Our ref: PS214031-WSP-SYD-STR-LTR-250724 RevA

**105 Miller St North Sydney
Structural Response to Metro RFI**

This letter has been prepared as an addendum to the WSP Report PS214031 – *105 Miller St – Proposed Development Impacts from Sydney Metro Infrastructure Structural Report* Rev A dated 2/07/25 to address comments from Sydney Metro following their review of the report.

DRAWING TITLE
SITE METRO PROTECTION ZONES - FINAL STAGE PLAN - COMMERCIAL SCHEME

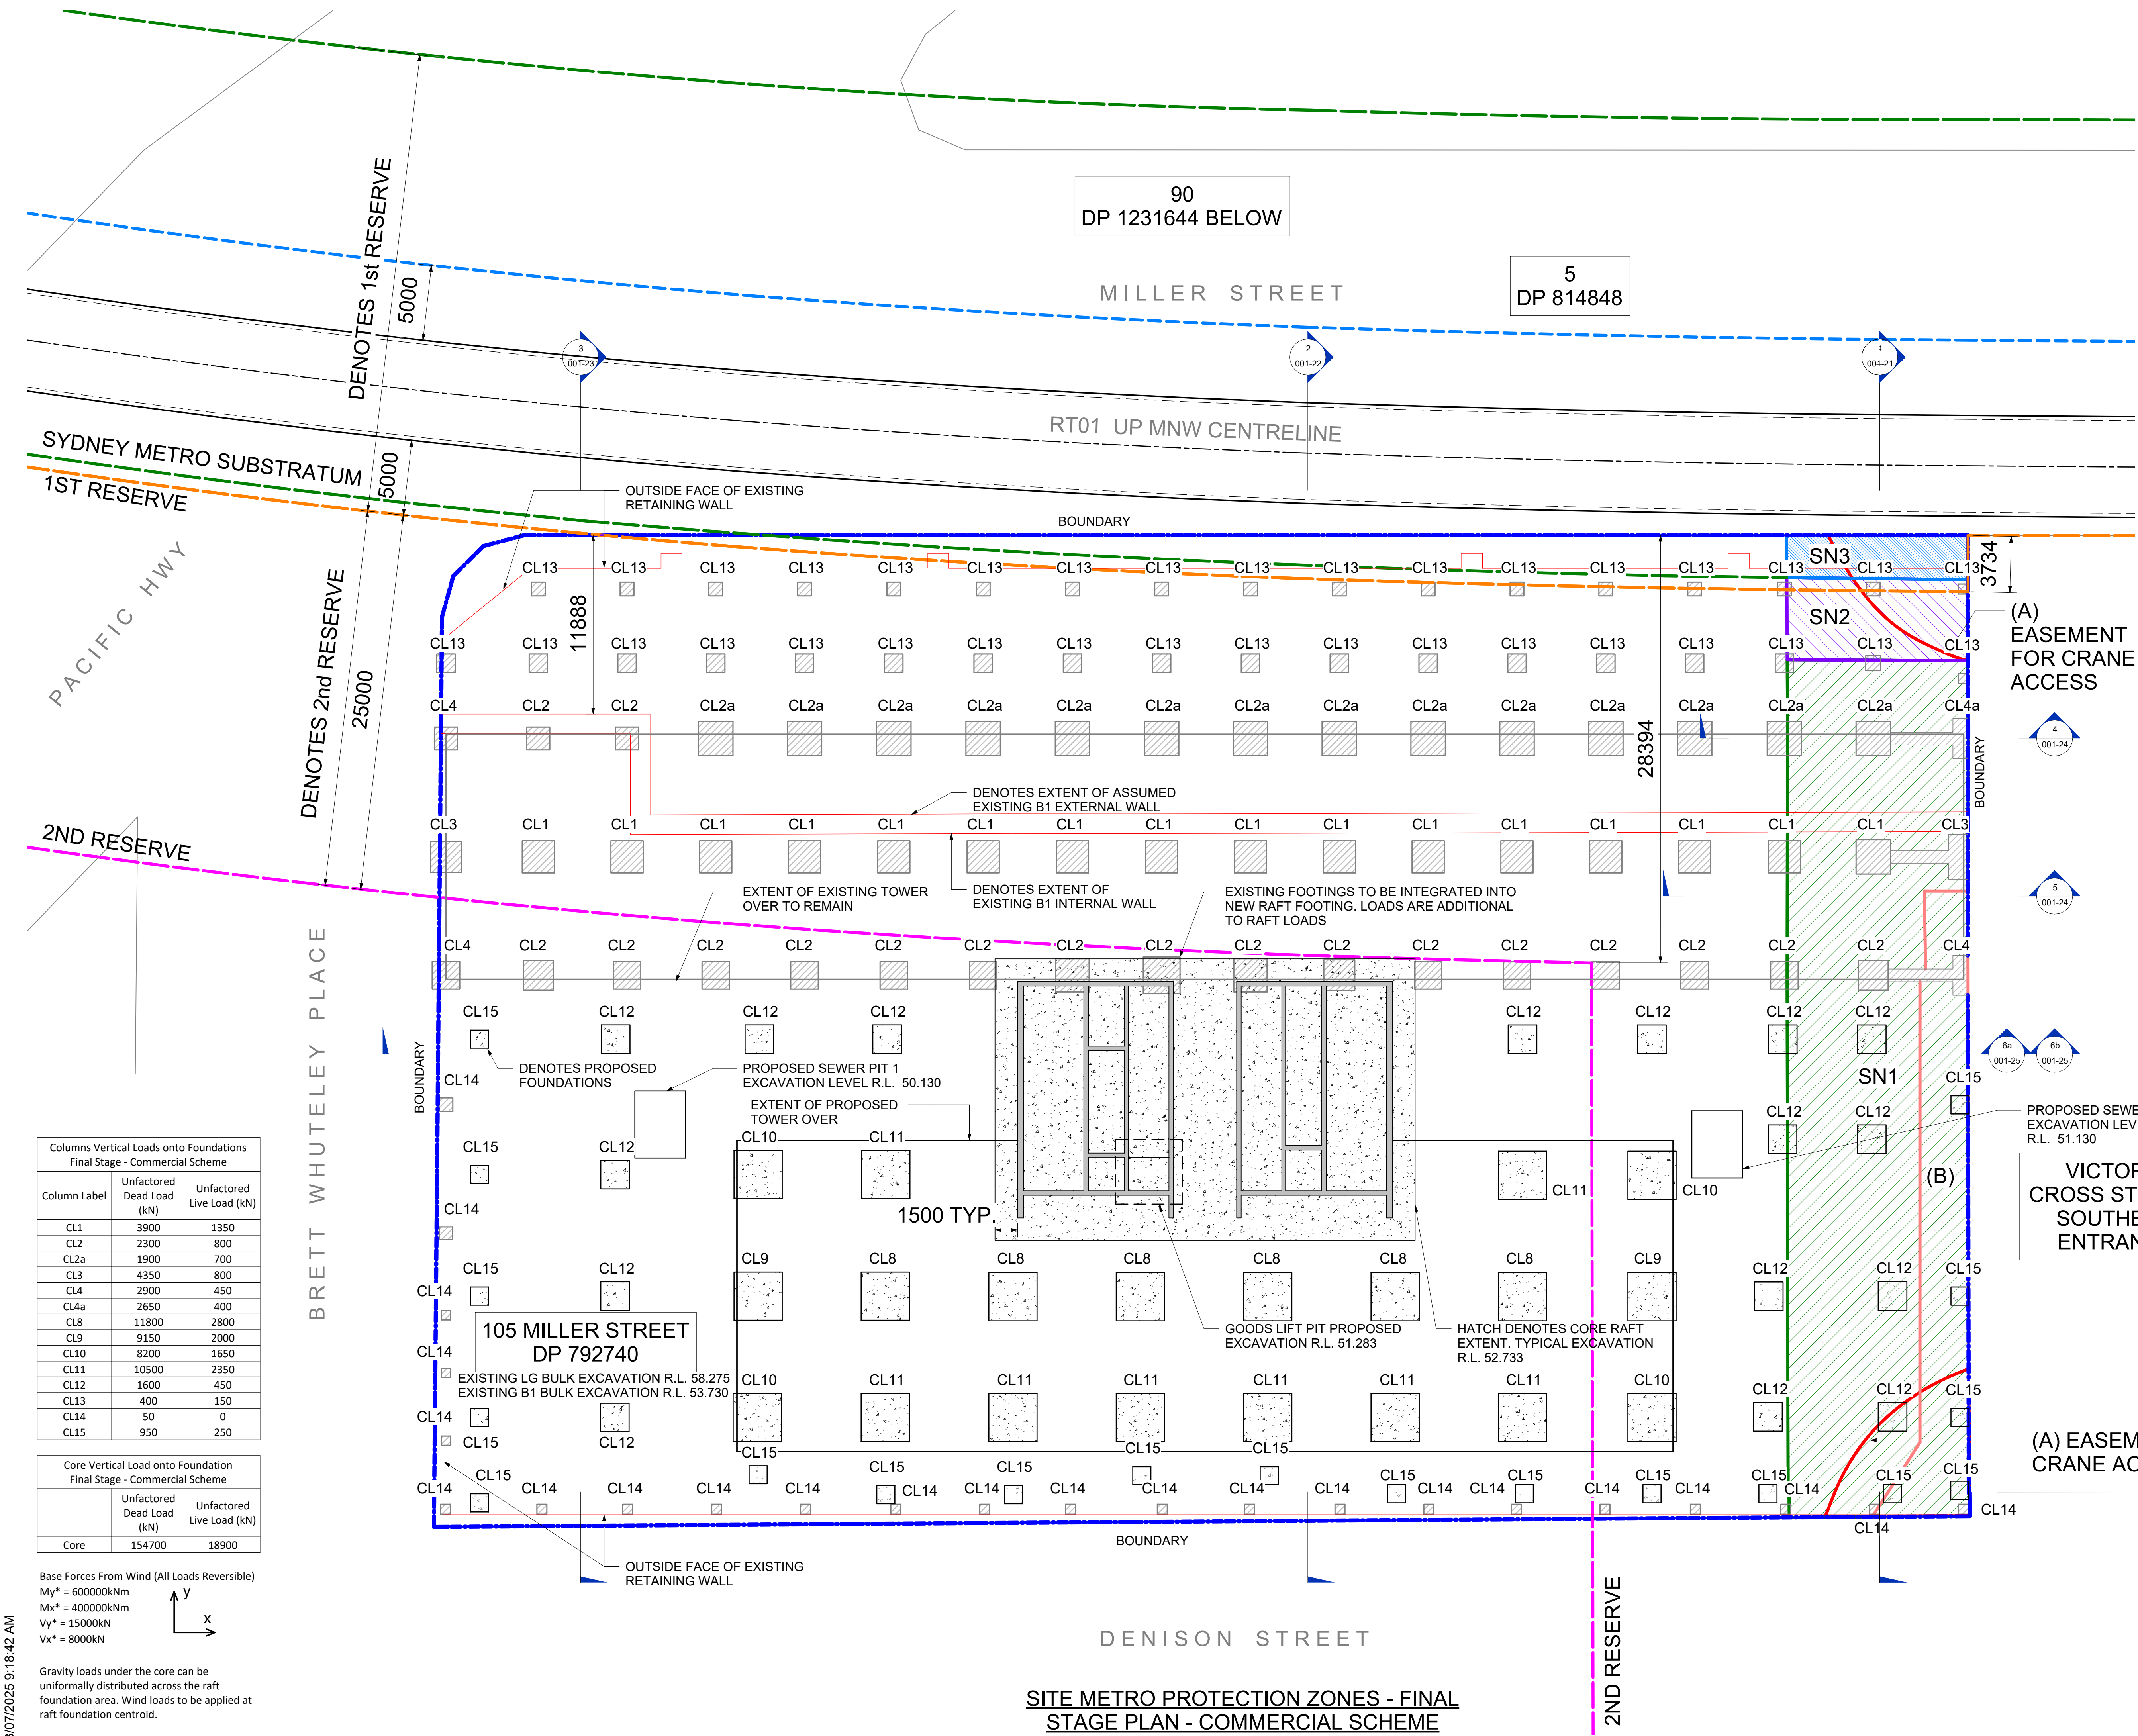
- *5.1.1 General: Building core hold-down anchors - they are shown on Section 1 & Section 3 models, but it is noted that these anchors are not shown on Appendix C "Provided Drawings"*
- *From Geotech impact assessment, it is understood that hold-down anchors are proposed. However, no discussions or descriptions are provided in the structural report.*

Building core hold-down anchors not shown on “Provided Drawings”

It is noted that all of the proposed permanent core vertical ground anchors are located outside of both the First and Second Sydney Metro Reserves.

The WSP 105 Miller St Site Protection Zone drawings have been updated to show all proposed core permanent vertical ground anchors, refer attached.

The permanent vertical ground anchors have been provided around the perimeter of the core as shown in the attached sketches. These anchors have been designed to be installed with the core raft construction and tensioned at time of installation to ensure that the nominated residual long-term load is provided in these anchors for the design life of the building (50 years). Under a lateral loading event the tension demands around the perimeter of the reinforced concrete core are resisted by the permanent vertical ground anchors.
